**Redevelopment of Scottish Hospital at 2 Cooper St, Paddington: MP10\_0160**

I am writing to object to the Presbyterian Aged care redevelopment at the old Scottish hospital site. The height bulk and size of the development have an adverse impact to the residents surrounding this site. The particular points of contention are:

19 Cooper Street Balcony RL 36.95 Existing

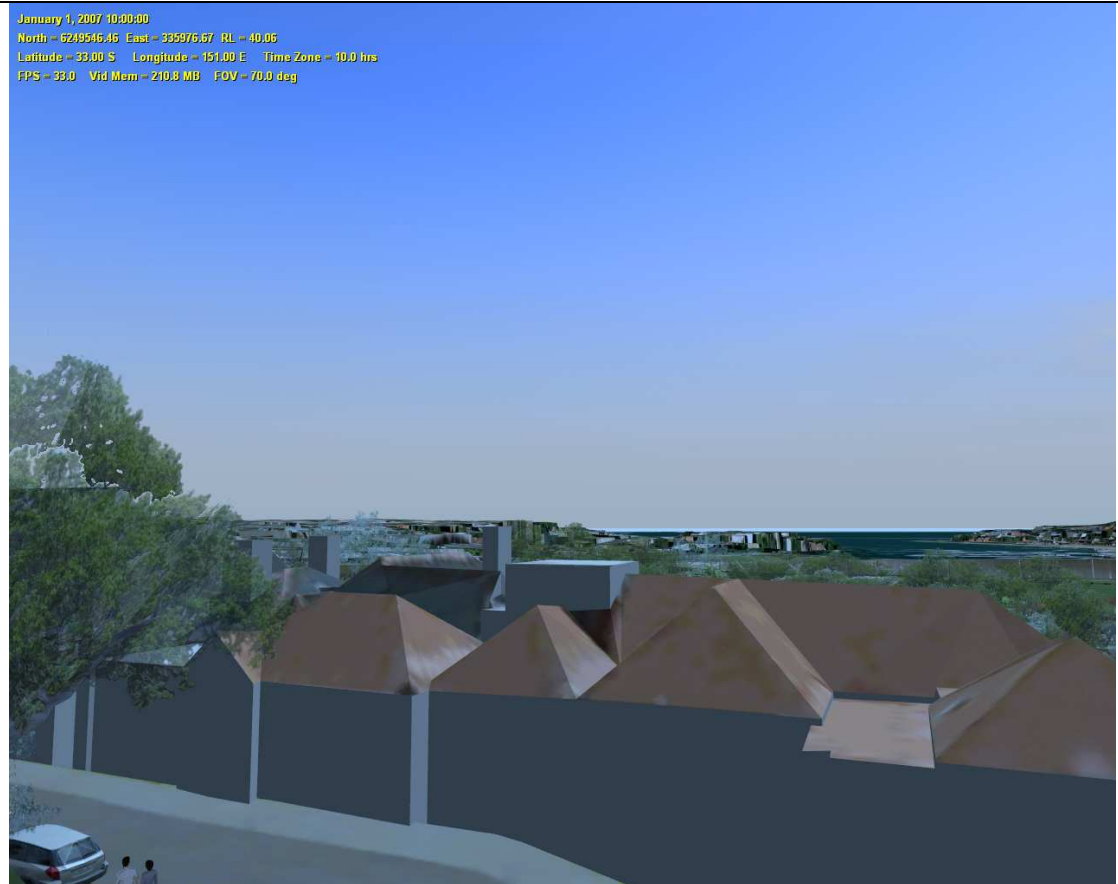
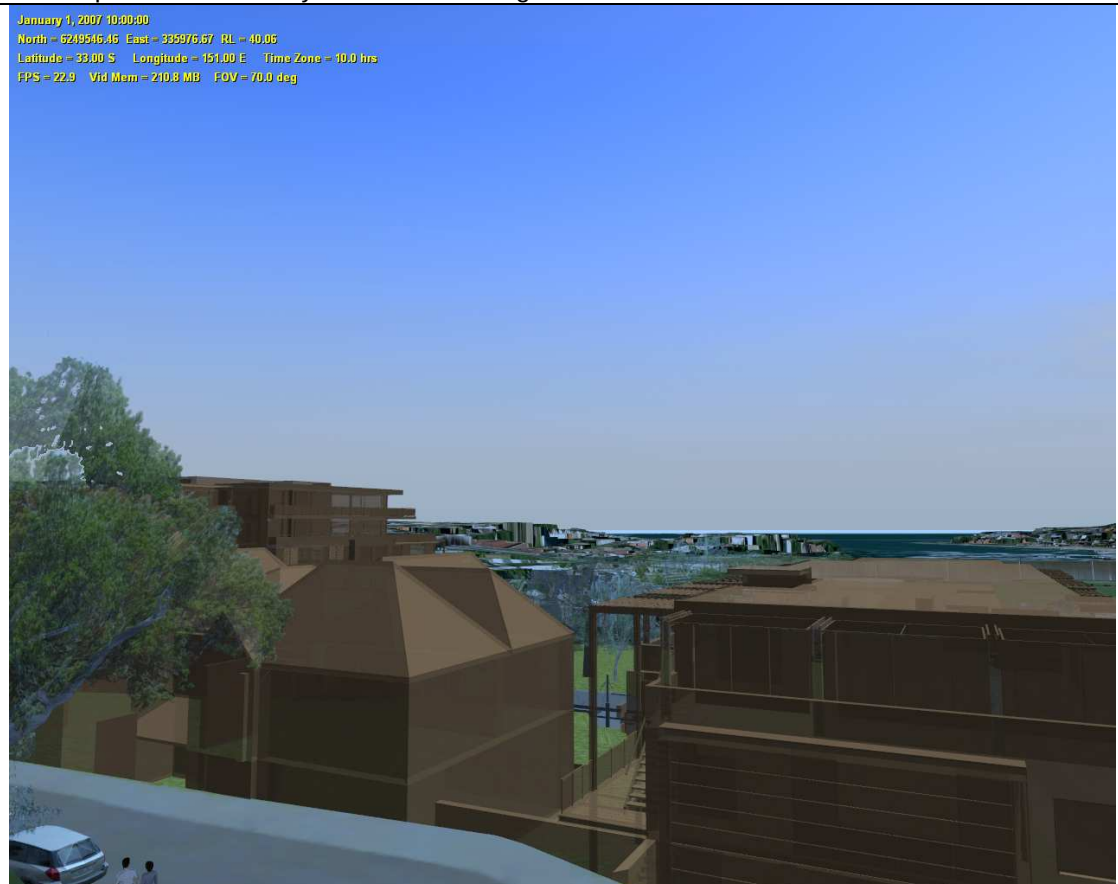
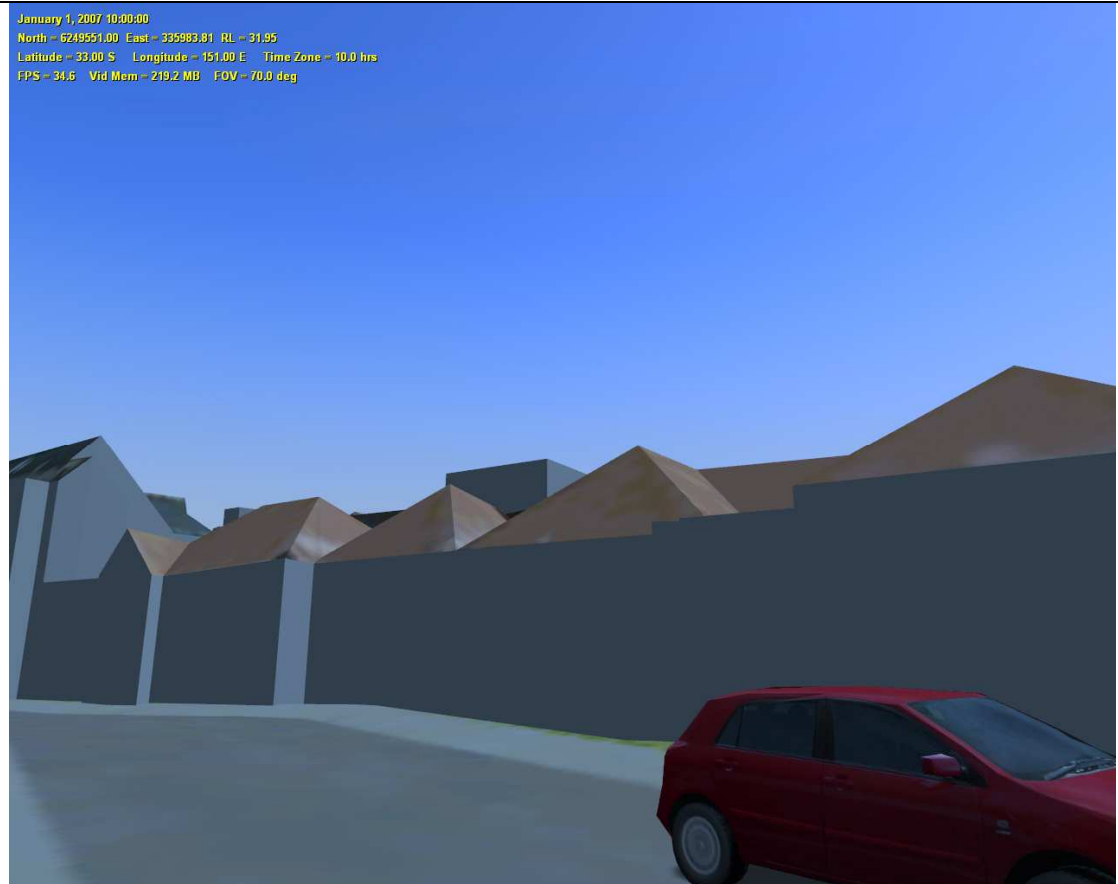
The new proposal increases the height of the structure in the South East corner above the present flat roof structure which affects sight lines. The result is an unfavourable view over a significantly larger, bulky building which is dominated by a grey roof and apartment. This is a grave change from the present green leafy northern views to the harbour (see photo Appendix).

The development in the South east corner needs to reduce its height. I object to the extra residential penthouse apartment that has been included on this South East build which will deteriorate the resident's aspect and views. The bulk of the new planned lift well is another point of contention. The proposal communicated a flat planted roof (without reference to the extra height from the self contained apartment). I would like to request the removal of this extra private accommodation level in order to retain the height of the existing flat roof structure. I would further request to have the lower revised flat roof structure completely planted with low cover vegetation to assist with the green aspect and alleviate the bulk and scale of the new proposed building. The visual amenities of current residents need to be protected. (See photo in appendix)
